From: Paul Cann
Sent: 27 September 2017 14:20
To: Planning.Responses
Subject: RE: Planning Consultation on AL/96/17/DOC

APPLICATION NO: **AL/96/17/DOC**

Site Address: Woodgate Farm Westergate Street Westergate PO20 3SS

Description of Works: Application for approval of details reserved by condition imposed under AL/51/17/PL relating to conditions 3-surface water drainage, 5-site set up during construction, 6-schedule of materials & finishes, 7-details of new screen fence, 8-dustbin enclosure details & 10-covered & secure cycle parking.

© This drawing is the copyright of Robert Clark Associates Limited It may not be copied or reproduced without their written authority	Scale	At original	Revision
	As shown	A3	B
Drawing Number	1726/D1.1

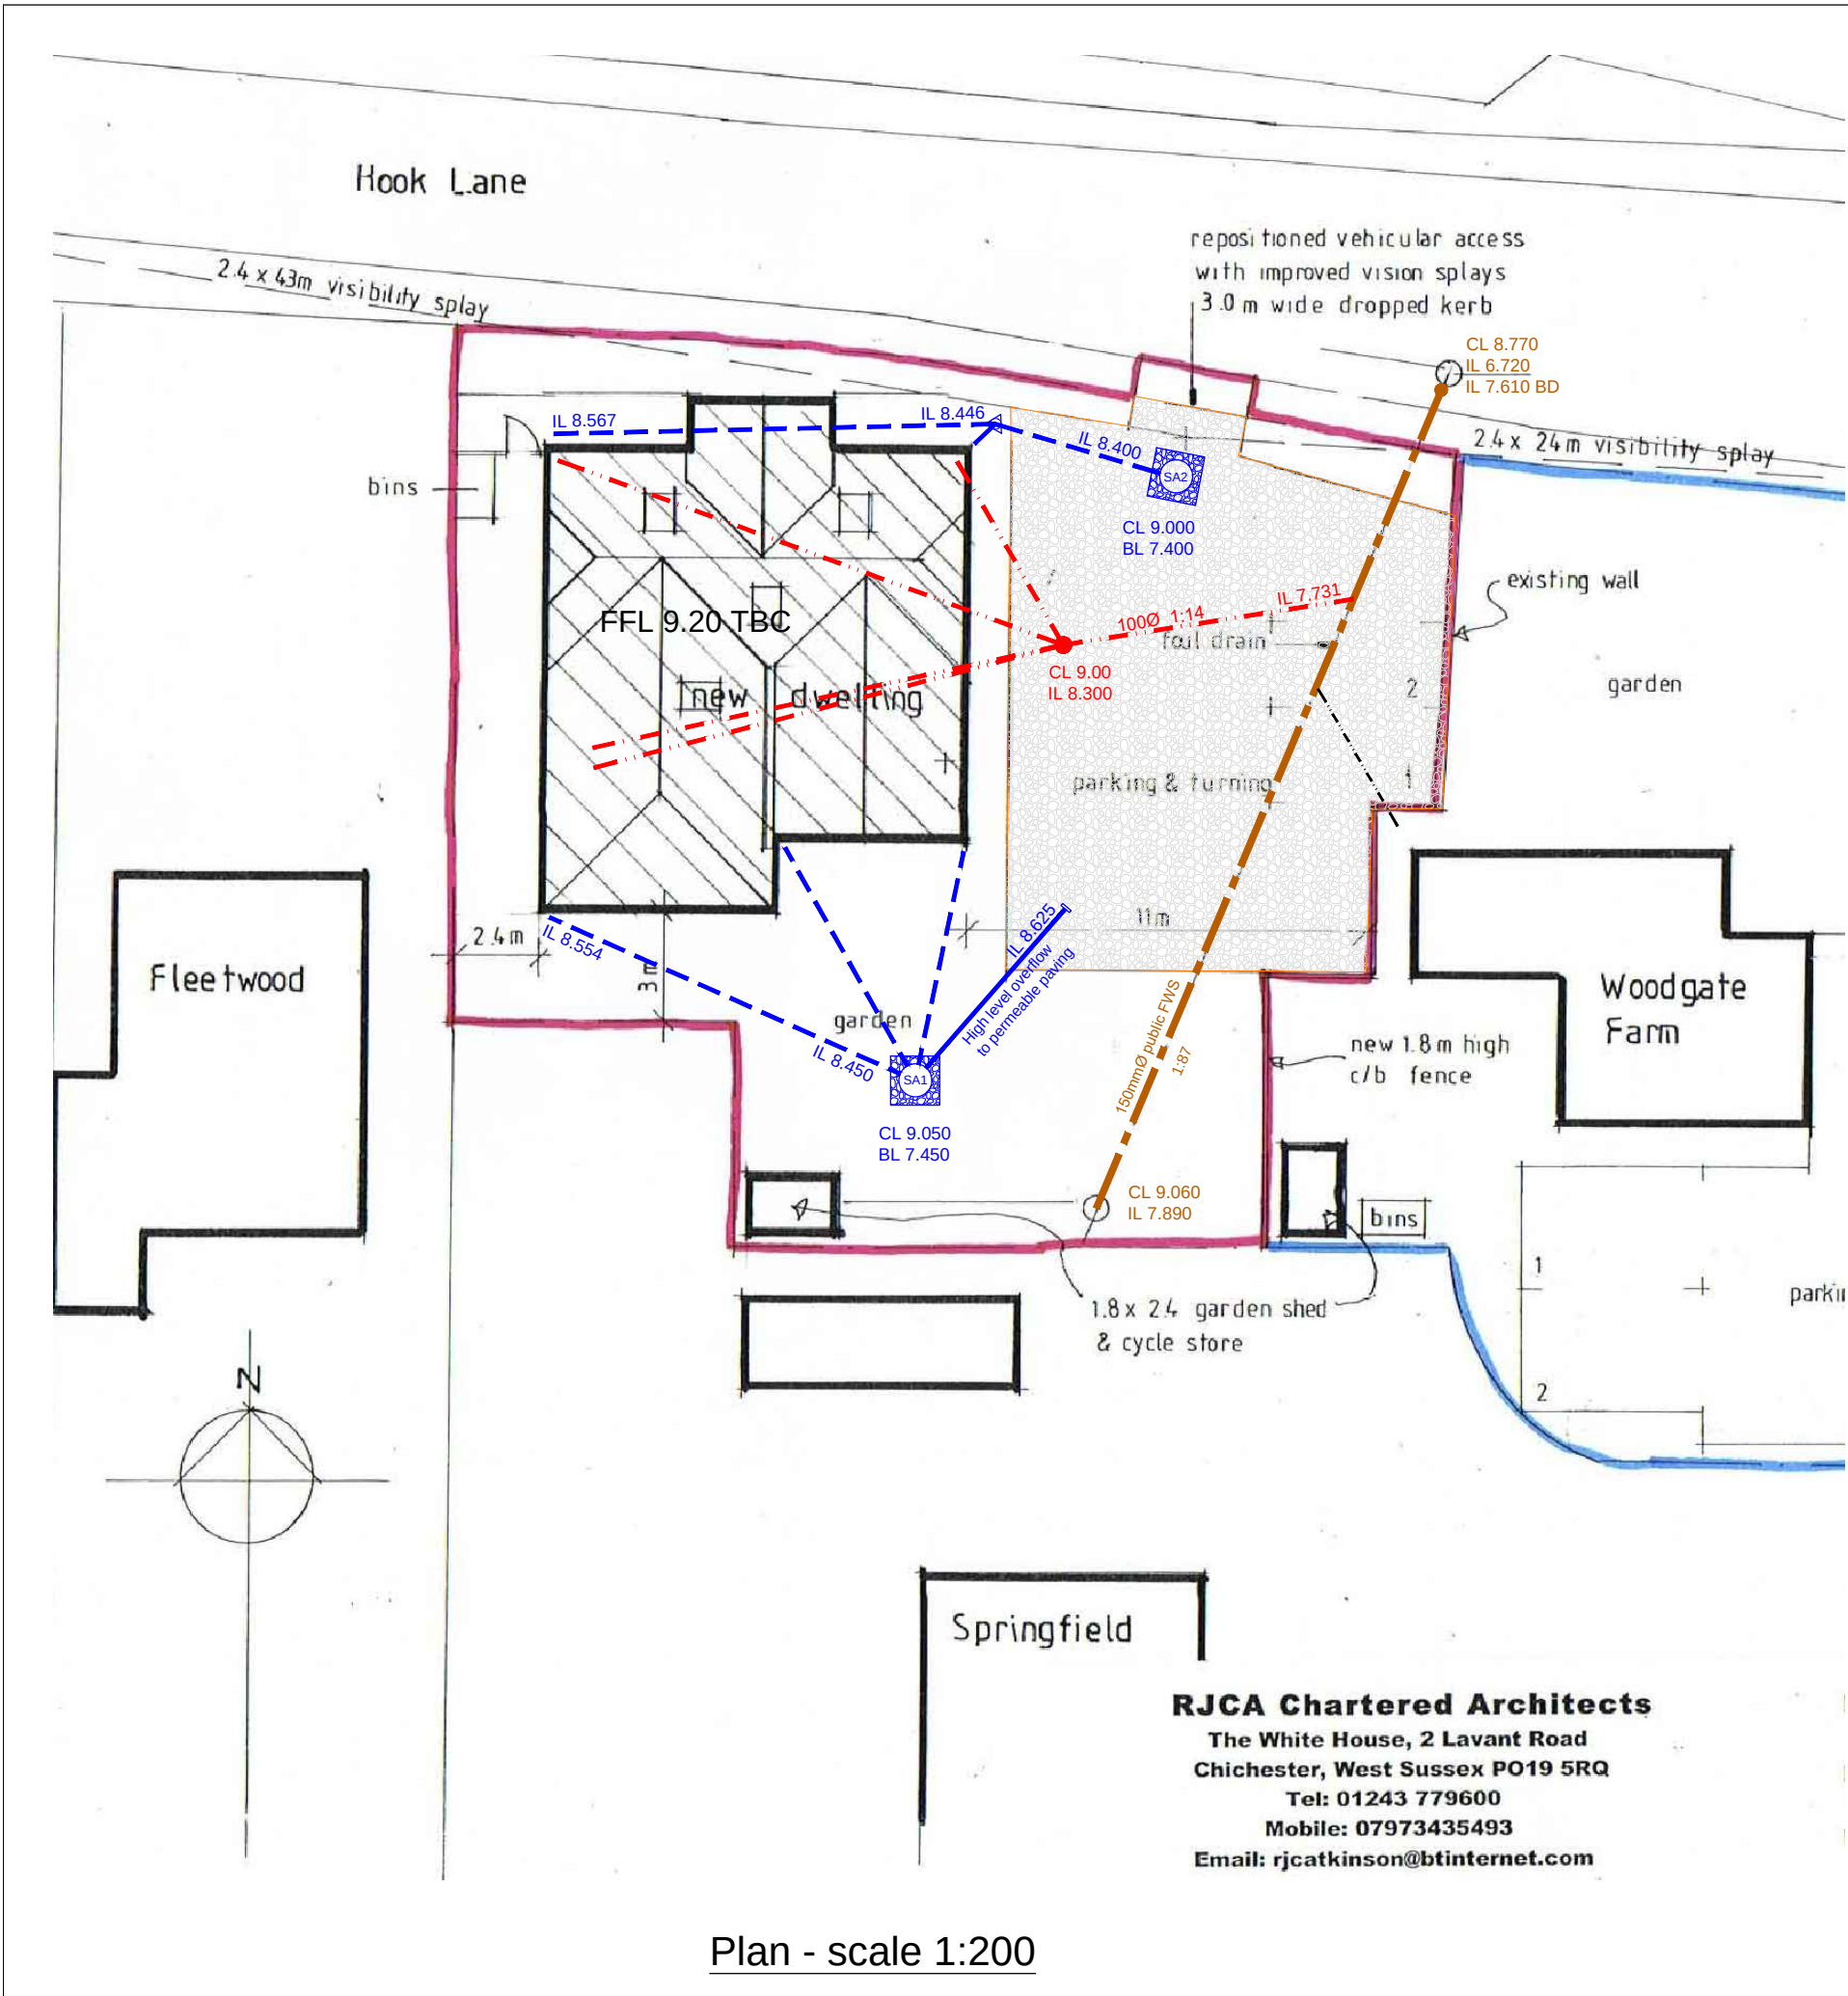
Condition no.3

In order to consider the proposals further, the following needs to be provided;

1. Full hydraulic calculations to prove that the 1in 100 year storm event + climate change allowance can be accommodated within the design.
2. Construction detail drawing for concrete ring soakaways, including the interaction with the permeable pavement adjacent SA2.
3. Construction detail drawing for permeable pavement, to include finished surface levels/base levels.
4. Specification for high level overflow pipe diameter/gradient/bedding & detailed arrangements for the end of the pipe where entering the permeable pavement sub base.
